Medworth Energy from Waste Combined Heat and Power Facility

PINS ref. EN010110
Document Reference: Vol 9.20
Revision: 8.0
Deadline 8
August 2023

Schedule of Changes (Deadline 8)

- Notes:
1. Proposed visibility based on New Bridge Lane being subject to a revised 30mph speed limit.
  2. New street lighting has been provided on an indicative basis (at 30m intervals and at conflict areas) and will require detailed design and assessment.

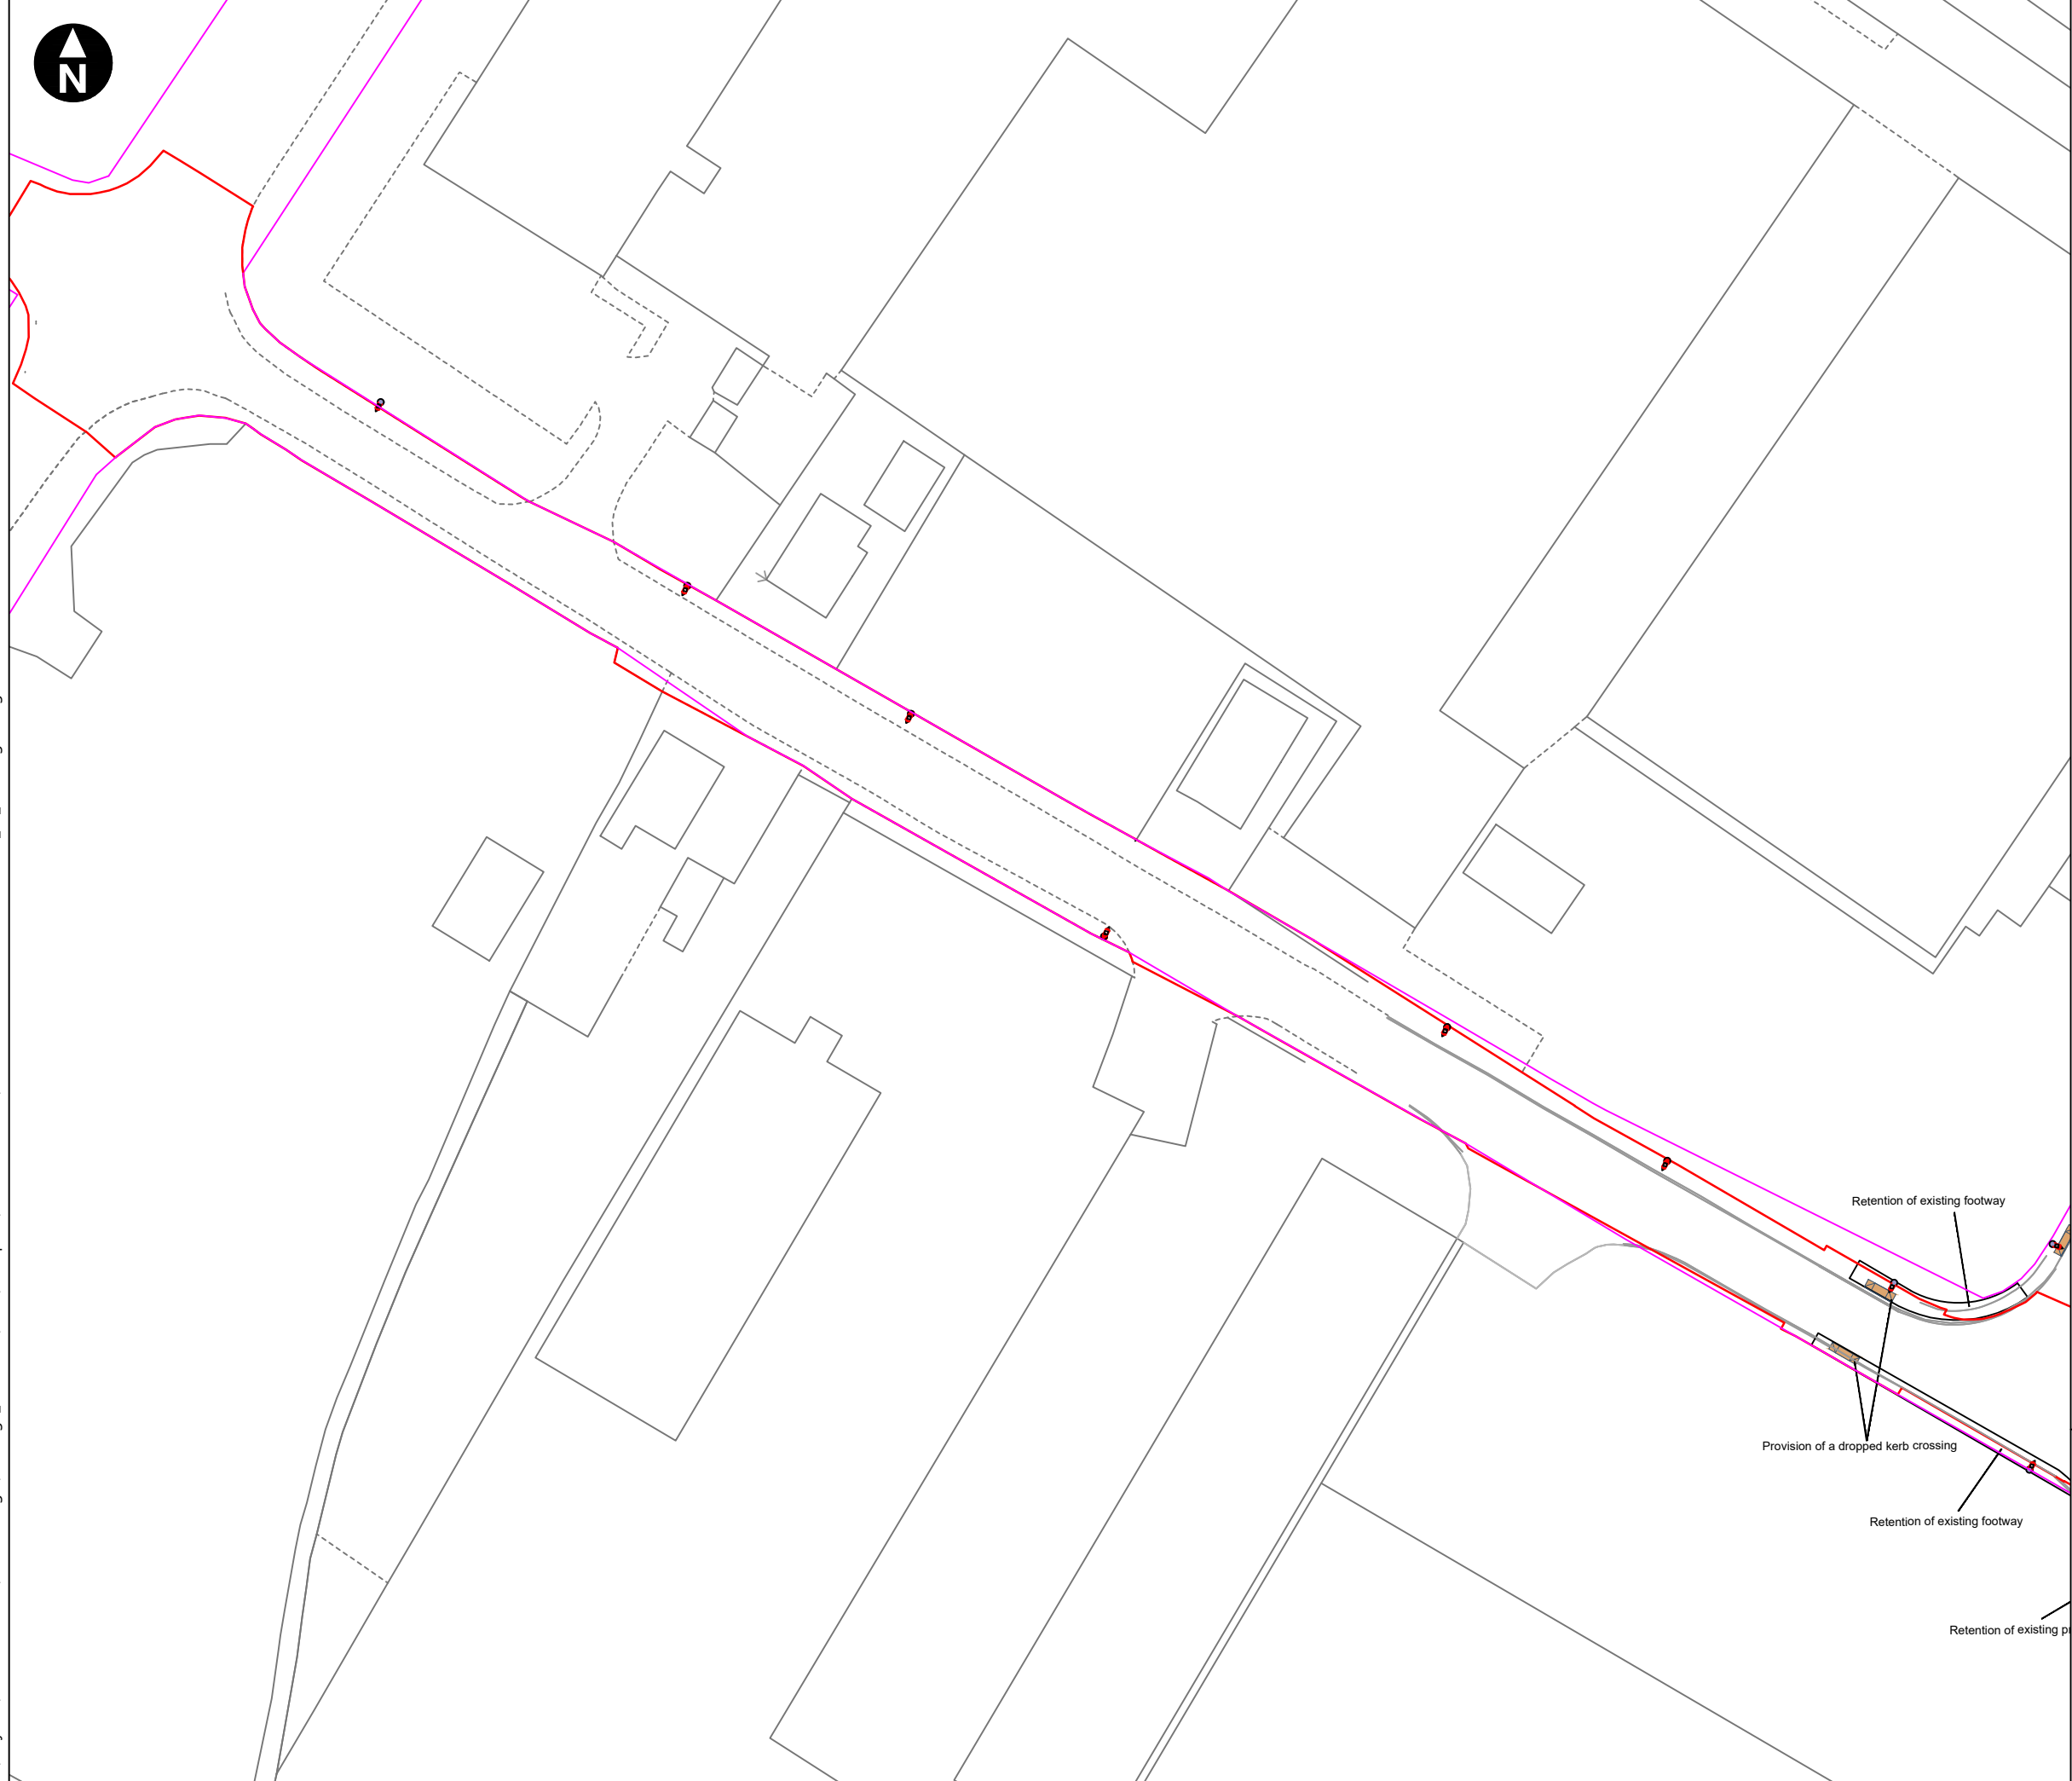
Volume 6.4 ES Chapter 6 Traffic	Additional drawings, Figures 9.2ii to show swept path of vehicle leaving New Bridge	CCC and FDC LIR paragraph 2.7.32 and 2.7.34 [REP1-074].	Deadline 3	Rev 3

Document Updated	Change	Reason for change	Deadline submitted	Relevant Document version
and Transport Appendix 6A Outline (CTMP) [REP1-011]	Lane. Also Figure 10.3i – ii to show outline design for construction accesses into the CHP Connection Corridor from Weasenham Lane and accompanying swept path.			
Volume 6.4 ES Chapter 7 Noise and Vibration Appendix 7D Operational NMP [REP1-012]	Reference to Applicant's intention to purchase 9 New Bridge Lane updated to confirm that the property has been purchased. Additional text added to 5.1.2 to include for the submission of a report to the relevant planning authority detailing the height, materials and acoustic performance of the acoustic fence to 10 New Bridge Lane for agreement ahead of construction.	CCC and FDC Comments on the Applicant's D1 Submissions (Outline CEMP) [REP2-031]. Outline Operational Noise Management Plan.	Deadline 3	Rev 3
Volume 6.4 ES Chapter 7 Noise and Vibration Appendix 7D Operational NMP [REP1-012]	New paragraphs 1.4.8 and 1.4.9 to provide a commitment to the preparation of an Operational Noise and Vibration Management Plan for the Walsoken Substation.	KLWN Relevant Representation [REP2-028].	Deadline 3	Rev 3

**Figure 4.1**  
**Proposed drainage strategy for Construction Phase**

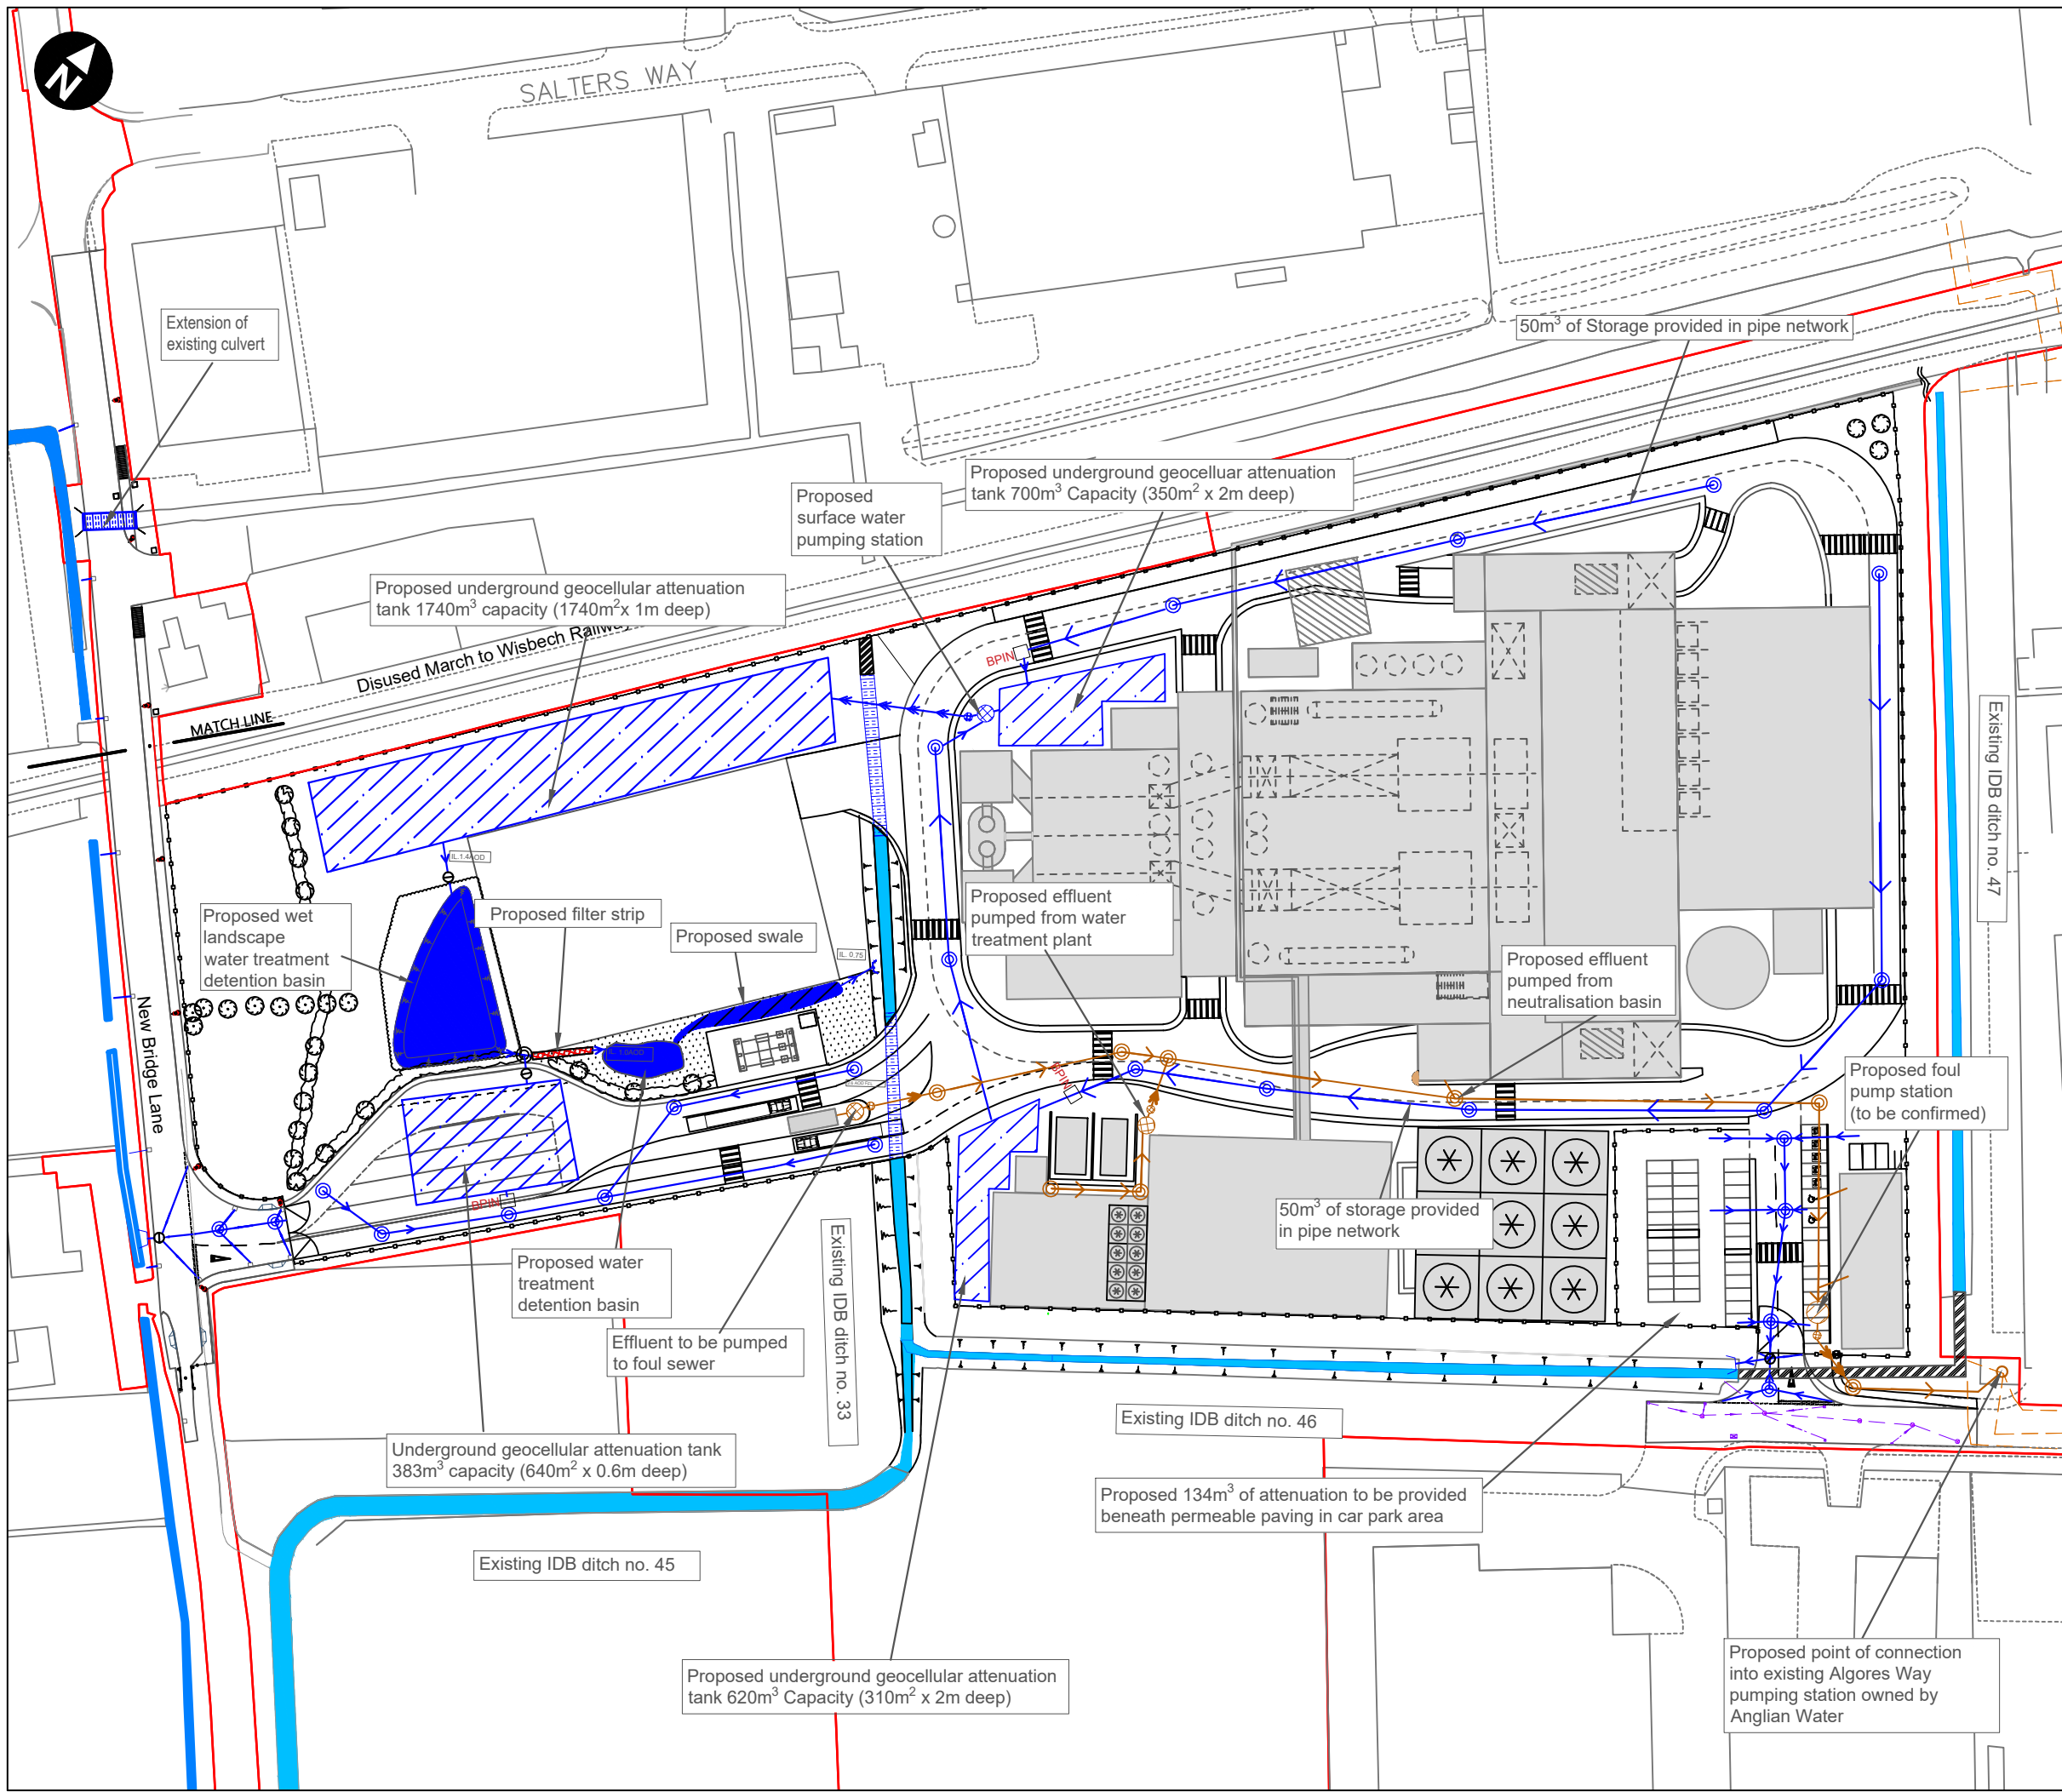
Document Updated	Change	Reason for change	Deadline submitted	Relevant Document version
	<p><u>Section 6 (Summary)</u> Minor amendments to the text to reflect the amendments to the Walsoken Substation and frequency for the replacement of straw bales text.</p> <p><u>Figure 4.1</u> Amendment of 0.5m high earth bund around the perimeter of the northern Efw area and TCC (i). Increase storage capacity of 3 No attenuation basins in TCC (ii).</p>			
Volume 7.9 Outline Flood Emergency Management Plan [APP-100]	Paragraph 2.1.3, Table 5.1 - emergency planners to be notified of any residual risks.	Environment Agency (EA) Relevant Representation [RR-014].	Deadline 1	Rev 2
Volume 7.9 Outline Flood Emergency Management Plan [APP-100]	Paragraph 1.1.3 – the Cambridgeshire and Peterborough Local Resilience Forum will be engaged in the production of the final plan.	FDC and CCC Joint Relevant Representation [RR-002 - RR-003].	Deadline 1	Rev 2
